PLANNING CONSULTATION RESPONSE

Application No	2026/0412
Proposal	Variation of conditions 2 (Approved Plans), 3 (Levels), 4 (Air Quality Mitigation), 5 (Trees), 6 (Highways Adoption Plan), 10 (Cycle Parking), 11 (Noise Mitigation), 13 (Boundary Treatment to Plots 1- 7), 15 (CEMP) and 16 (Hampton Windows) of planning application 2021/1405 : Reserved matters (appearance, landscaping, layout and Scale) application for development of 91 homes, structural planting and landscaping, surface water attenuation and associated infrastructure in connection with outline planning permission 2017/1718 (Outline planning for up to 102 homes) (Amended Plans)
Address	Former William Freeman Site, Wakefield Road, Mapplewell, Barnsley, S75 6ND
Date of Consultation Reply	18/06/26
Consultee	Nik King, Senior Urban Design Officer

These are the design comments for planning application 2026/0412.

Document Reference:						
Project	Originator	Functional	Spatial	Form	Discipline	Number
VWYM2	PHS	FT	XX	DR	A	07022
FT50/70 Housetype						
Status:						Revision:
Code	Description					Code
S2	INFORMATION					P01
Created By:	Authorised By:	Date of first issue:			Scale at A3:	
ELC	CL	07.05.26			1:100

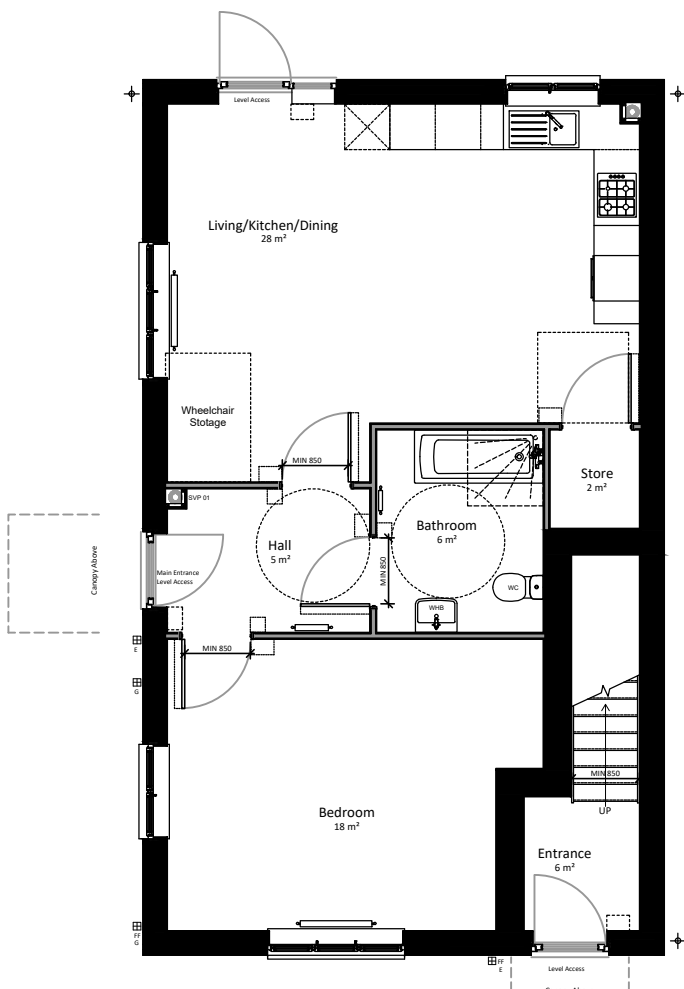
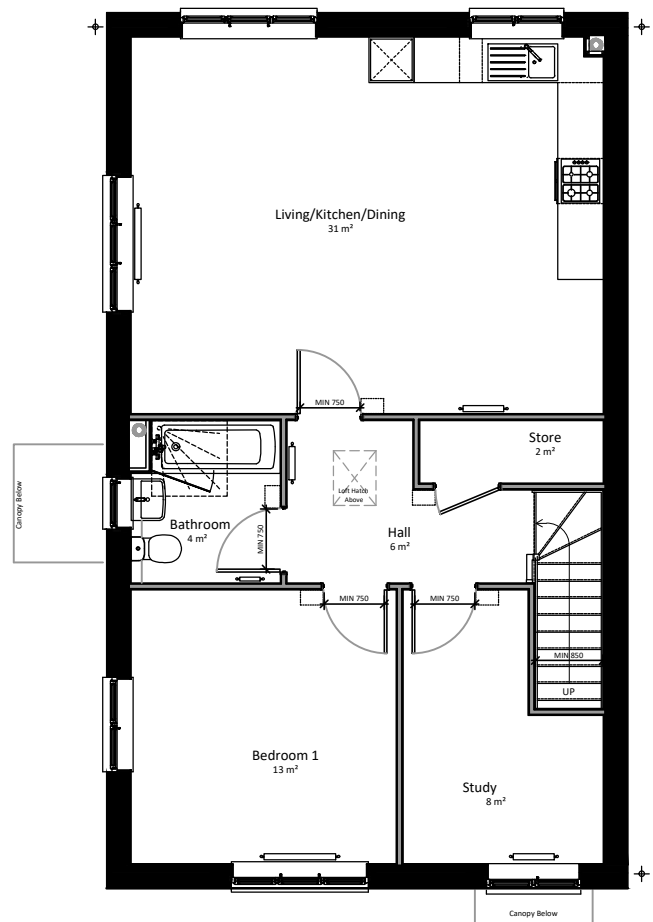
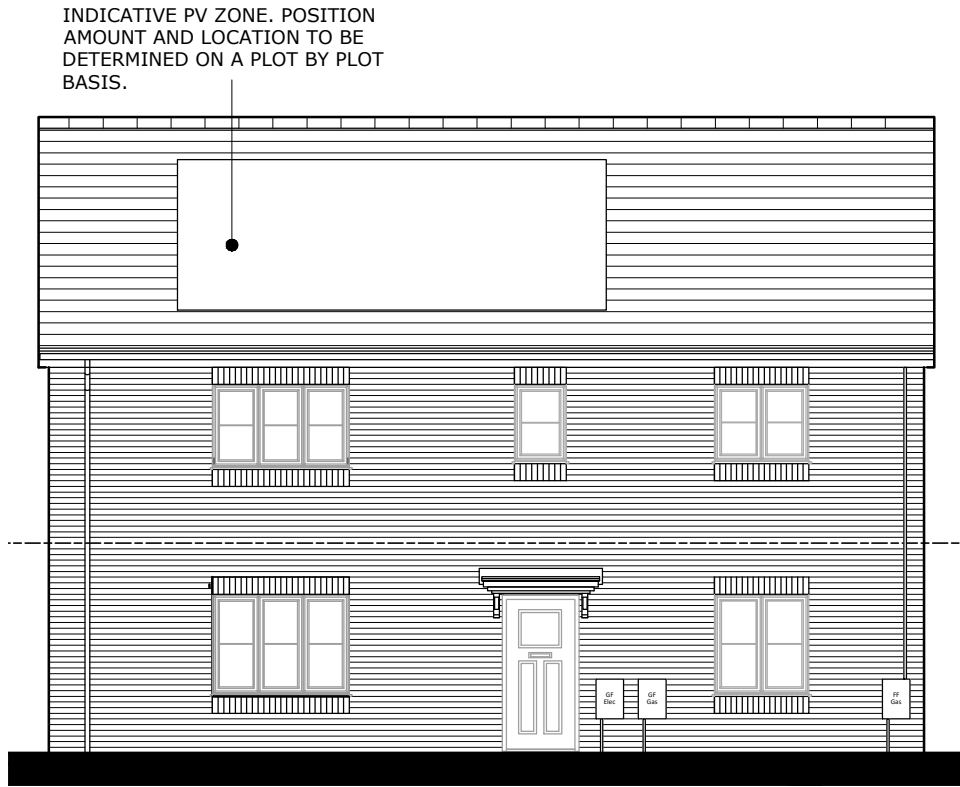
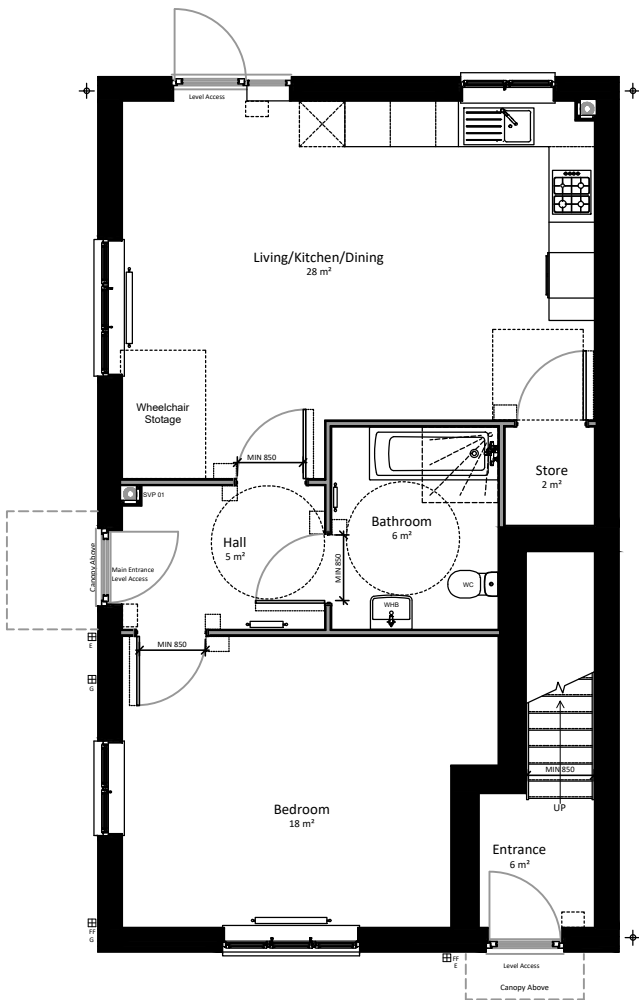
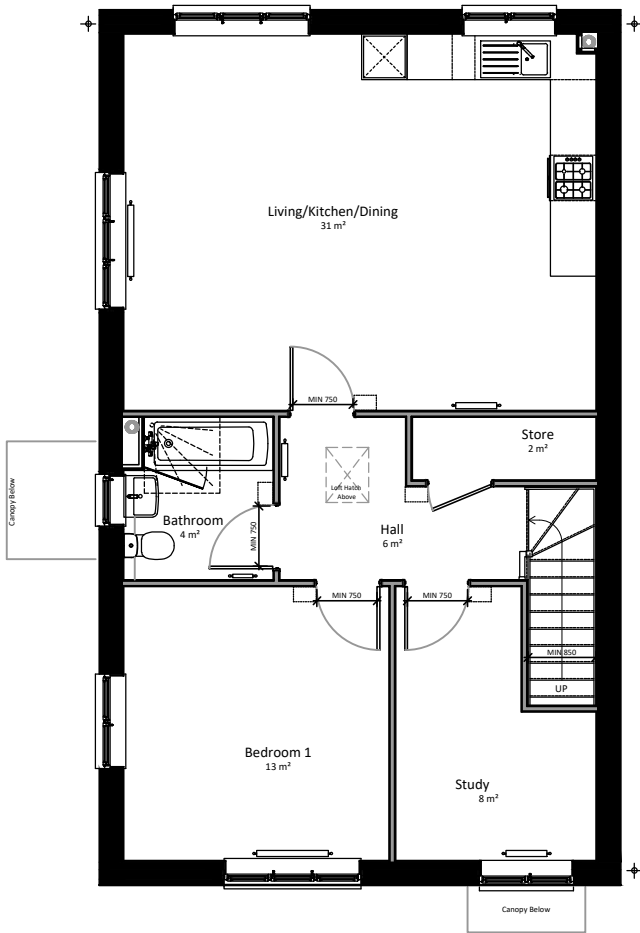
- We need more information about the **specification of the materials**, (for example for the walling, tiling, window frames, doors), preferably listed on the housetype plans.
- **Regarding the provision of accessible dwellings**, for the approved application I note that one M4(2) and two M4(3) are listed in the accommodation schedule (on the 'proposed site layout, Rev L'). In the current application, below the accommodation schedule on the 'M4 and Affordable Housing Plan, Rev P03', there is a note 'F50/70a GF will be delivered as M4(3) compliant and plot 78 is to suit M4(2) standards

currently'. With three F50/ 70a units being provided, I make this a total of one M4(2) and three M4(3) units, so there is a net increase of one M4(3) unit. Please note that in our most recent update for the local validation requirements, we now ask for the M4(2) and M4(3) labels to be shown on the site layout plan, the house type plans (stating 'M4(2) compatible' or 'M4(3) compatible') and on the accommodation schedule.

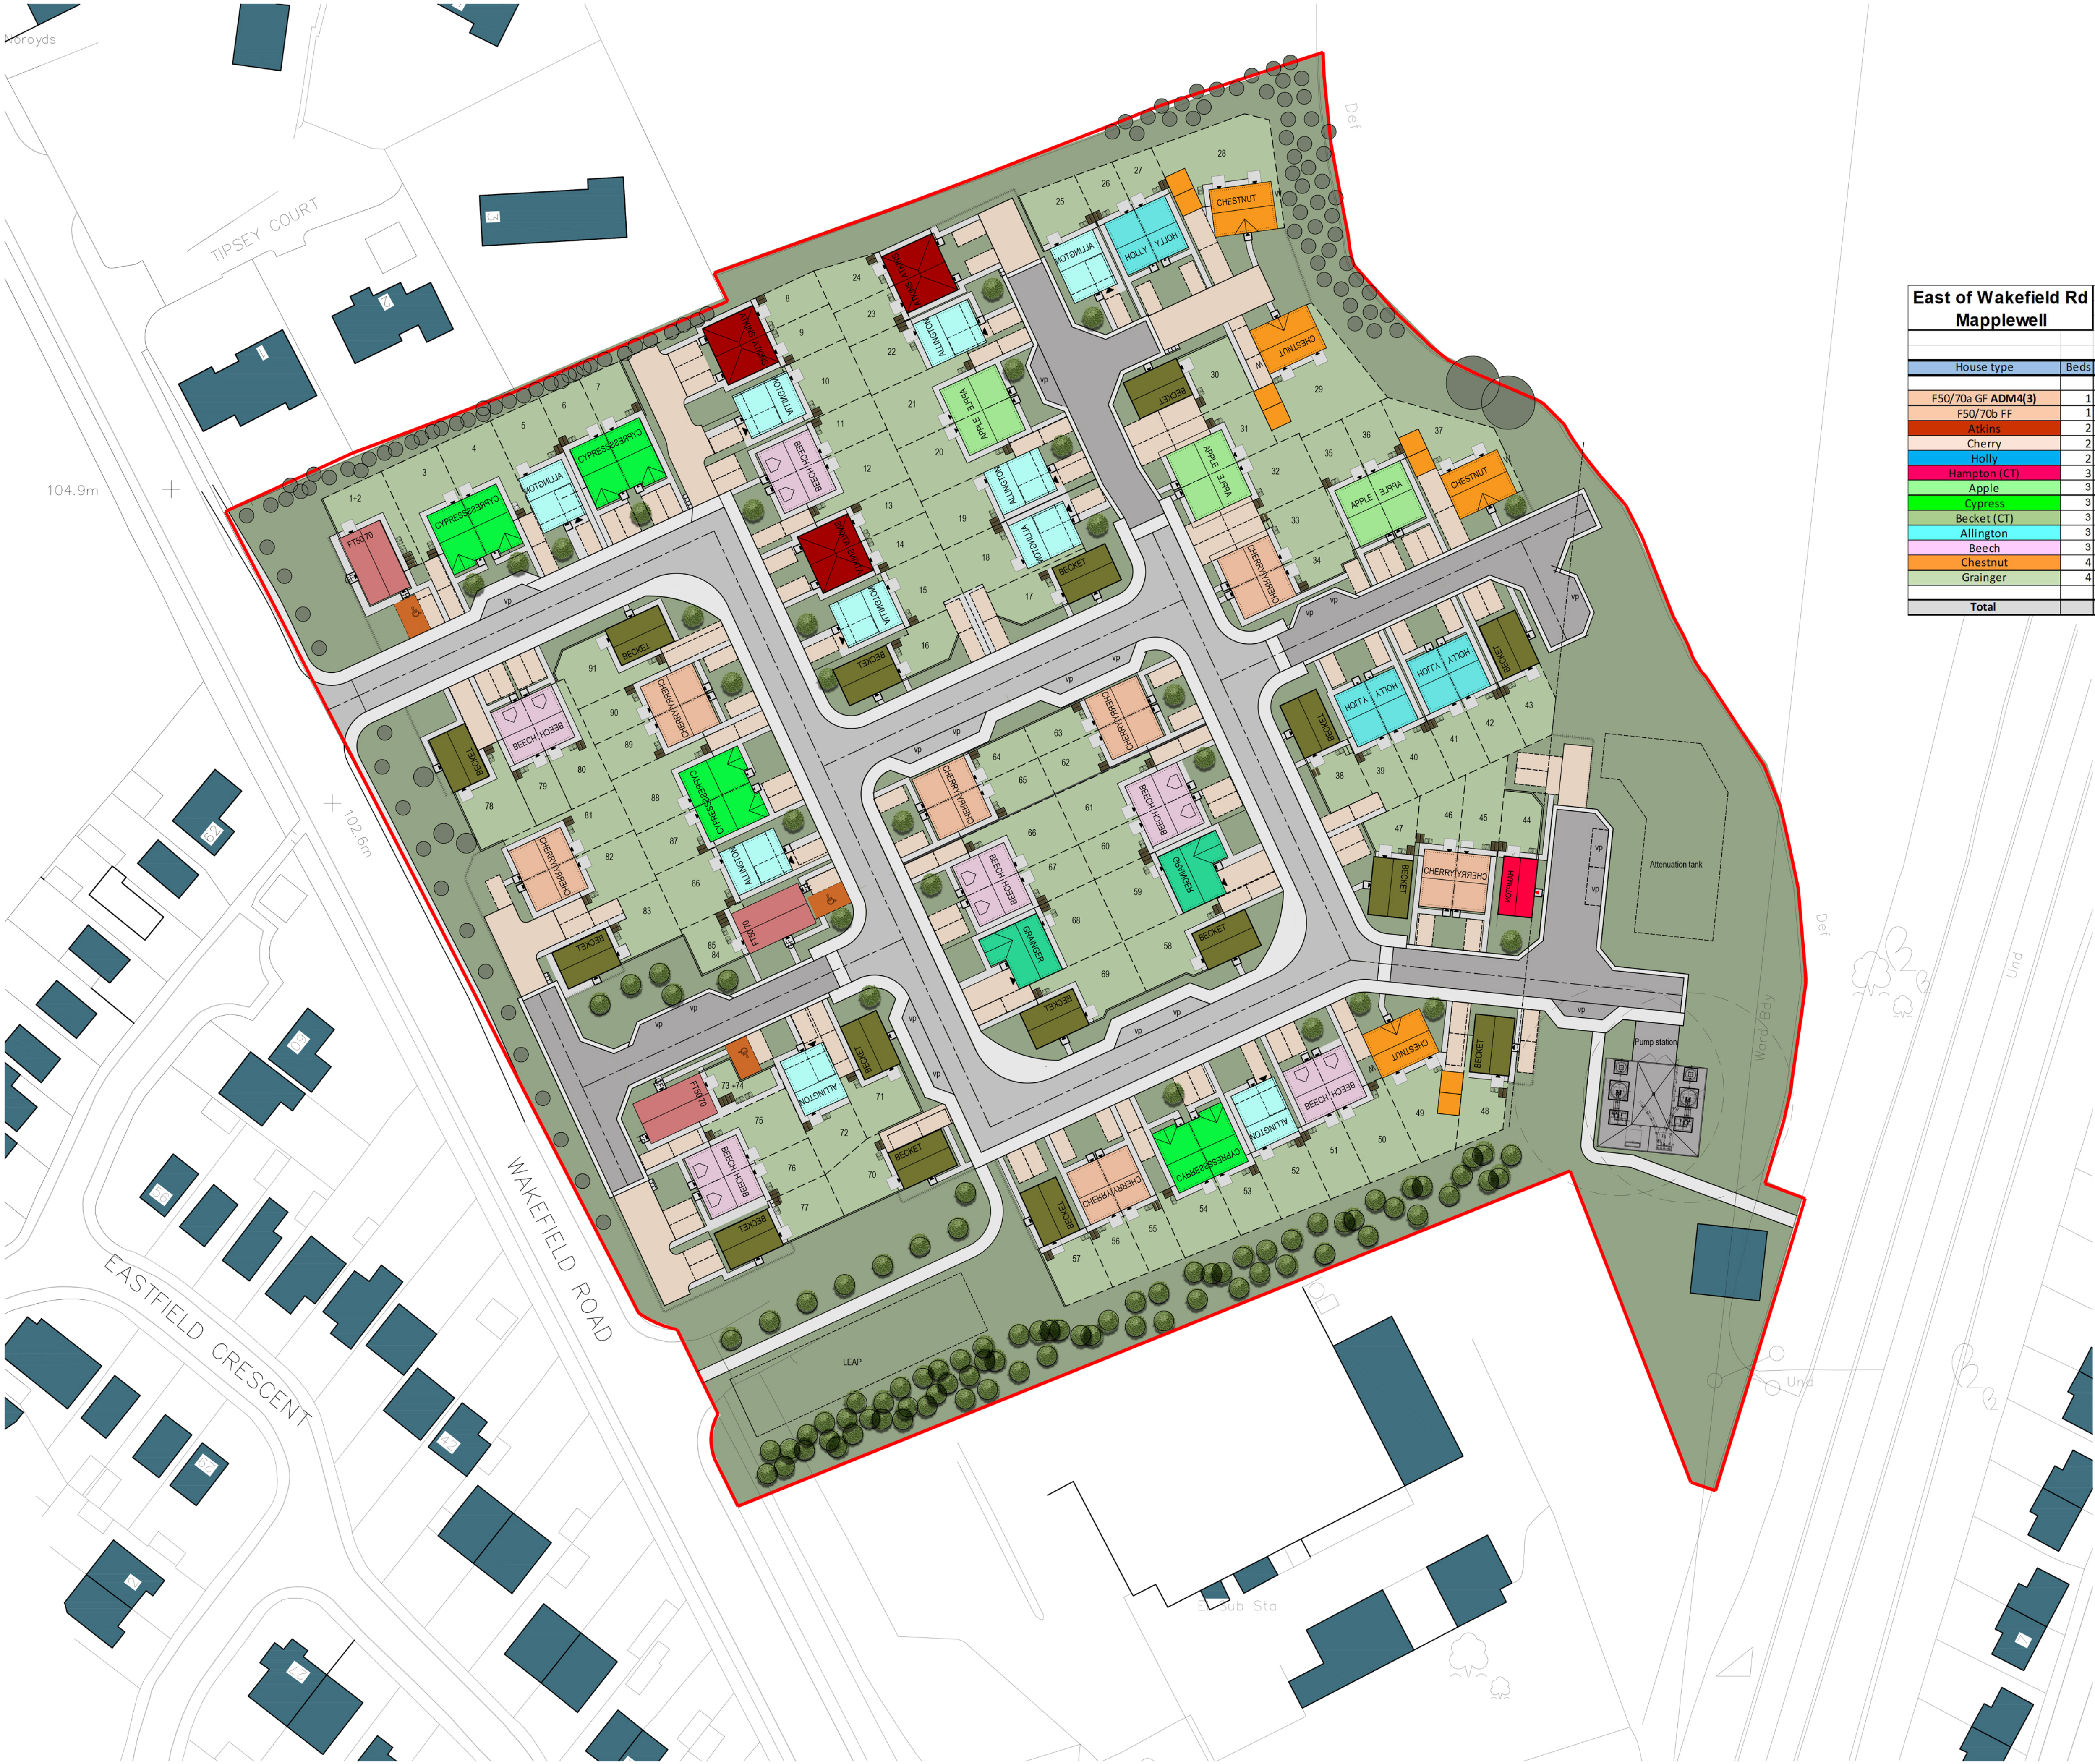
One of the main issues with the current application is the **overdominance of front-of-dwelling parking**.

However, on the layout plan for the current application, (I have used the drawing 'Landscape General Arrangement'), I count three stretches of overdominance of car parking. Given my stated concern above, about the use of thin strips of hedging to separate runs of parking bays, I count a further five stretches of overdominance of front of dwelling parking by default.

So, before with the reserved matters approval there was only one stretch of overdominance of front of dwelling parking, but now in the current application there are eight stretches of overdominance of front-of-dwelling parking.

This has also significantly reduced the number of trees being proposed to be provided in front gardens. The NPPF (in para 136) asks for new streets to be tree lined.

Another issue is with **the amount of visitor car parking**. I note that the approved reserved matters layout plan shows 17 visitor parking spaces whereas the proposed layout plan shows 14, a reduction of 3 spaces, for the same number of dwellings (91). The SPD 'Parking' recommends (on page 7) '*1 visitor space per 4 dwellings subject to layout. Flexibility for visitor parking will be considered on a site by site basis.*' I defer to Highways Development Control for any further comments on visitor parking provision for this proposal.
